**Loreto Normanhurst School Redevelopment (Concept Proposal and Stage 1)
91-93 Pennant Hills Road, Normanhurst (SSD-8996)
Notice of Exhibition**

TAB A – Detailed Comments on SSD-8996

Figure 12: Historical Crash Locations

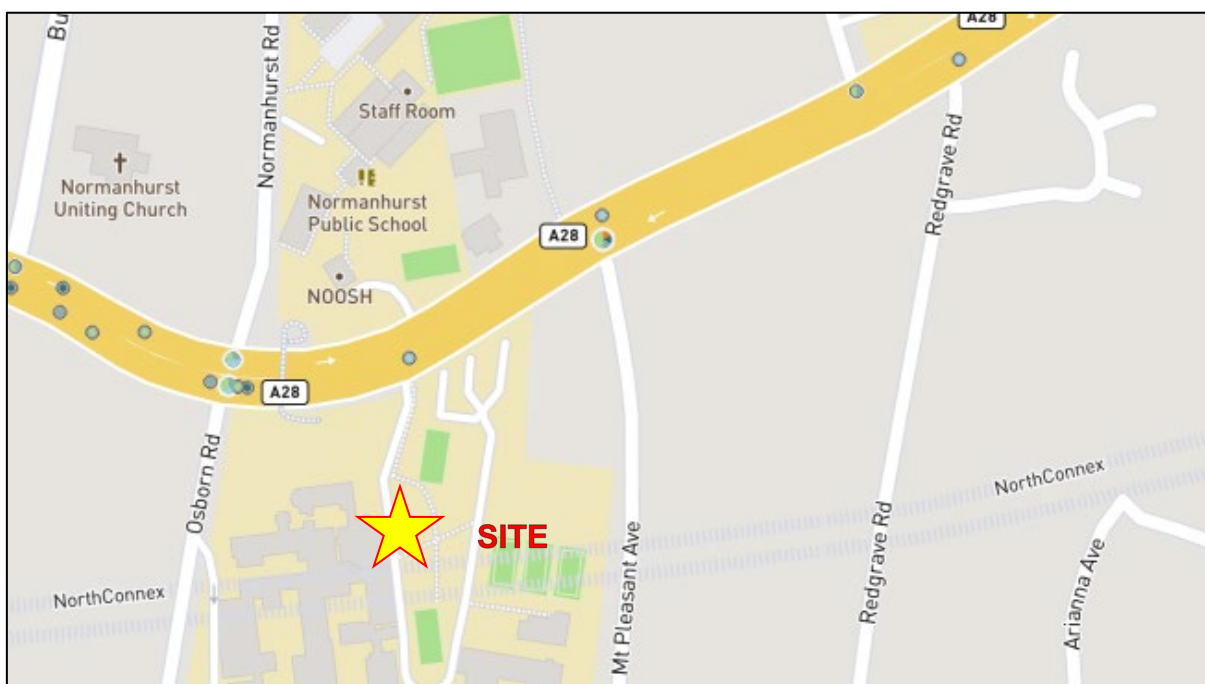
The analysis of historical data at Section 5.4 of the TA indicates a number of vehicle crashes associated with vehicles turning into or out of Mount Pleasant Avenue (three instances of right-through crashes and one instance of left-near crash). A fatal crash was also recorded at this intersection.

Having regard for the above, DPIE should consider requesting an investigation into traffic management measures or development design to mitigate potential increases in the occurrence of crashes due to existing and additional pick-up/drop-off movements and on-street parking on Mount Pleasant Avenue associated with the school.

Figure 14: Additional Traffic Generation: 2027

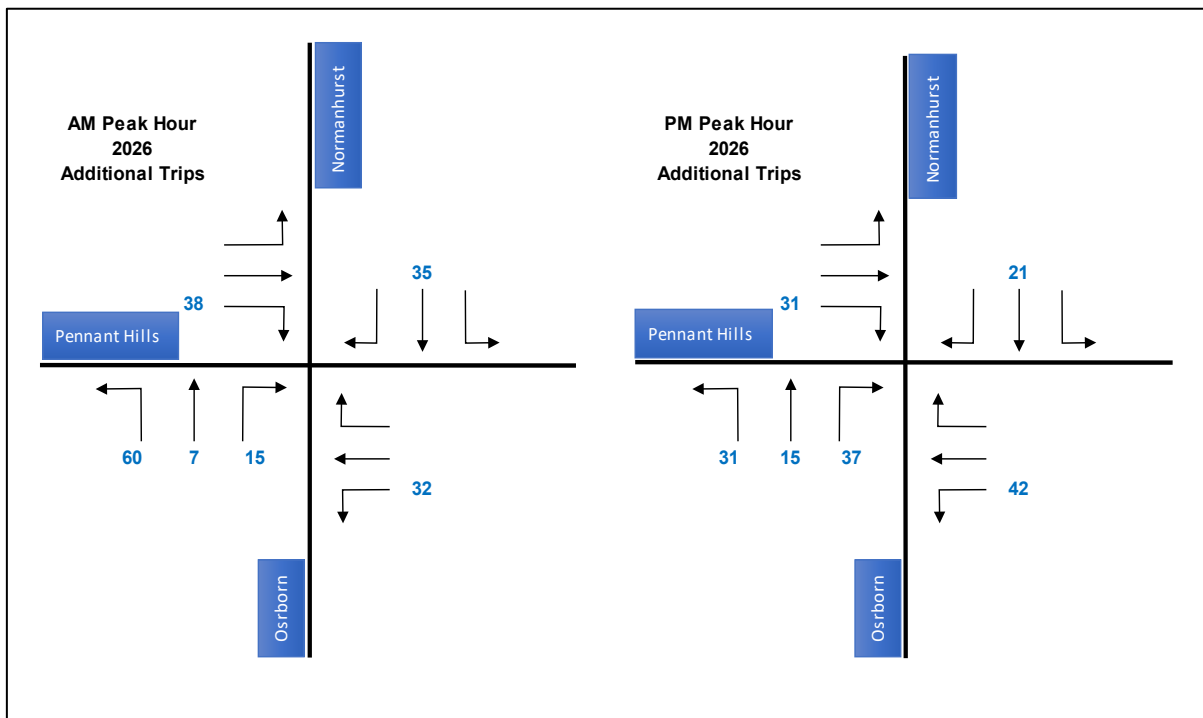
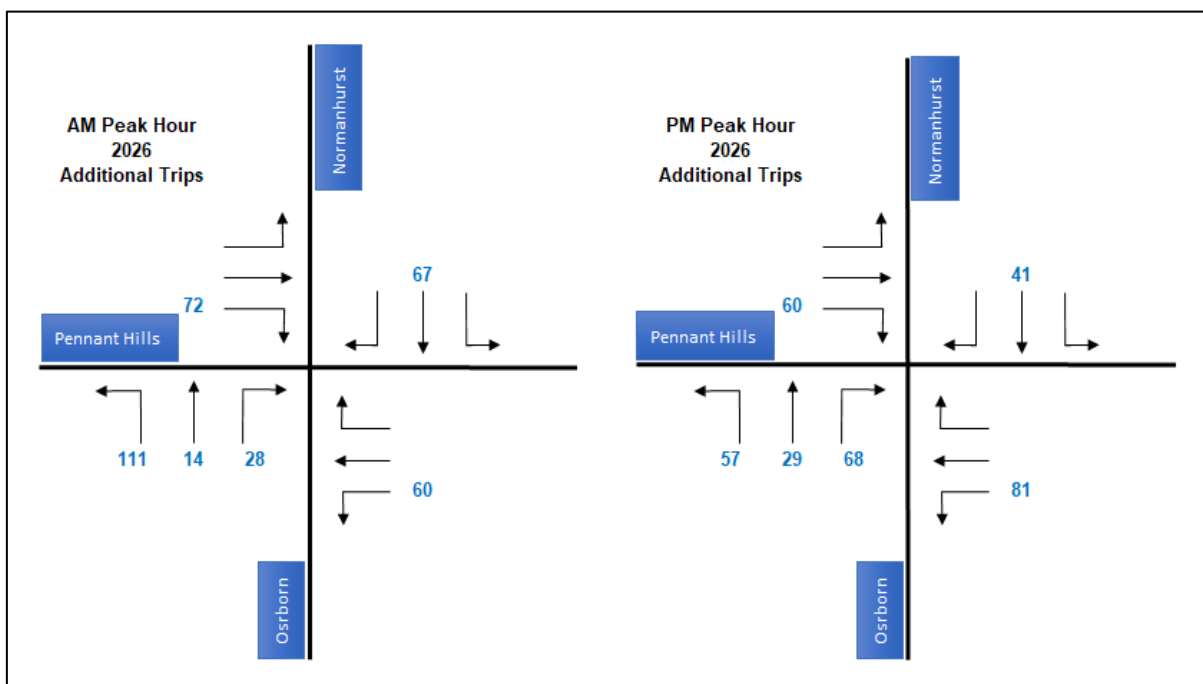
Section 4.5-4.6 of the TA provides an indication of the percentage of staff, students and parents/guardians utilising surrounding local roads or school grounds to travel to/from school based on travel surveys. It is stated that movements occur on Mount Pleasant Avenue, Osborn Road and Normanhurst Road. However, the TA assigns all traffic generated by the development to the intersection of Pennant Hills Road with Osborn Road, which is not reflective of existing access preferences by staff, students and/or parents/guardians.

The Applicant should consider the existing travel preferences and availability of on-street parking, pick-up or drop-off in the surrounding local road network to estimate trip assignment. Intersection analysis of all impacted intersections should be revised or undertaken accordingly.
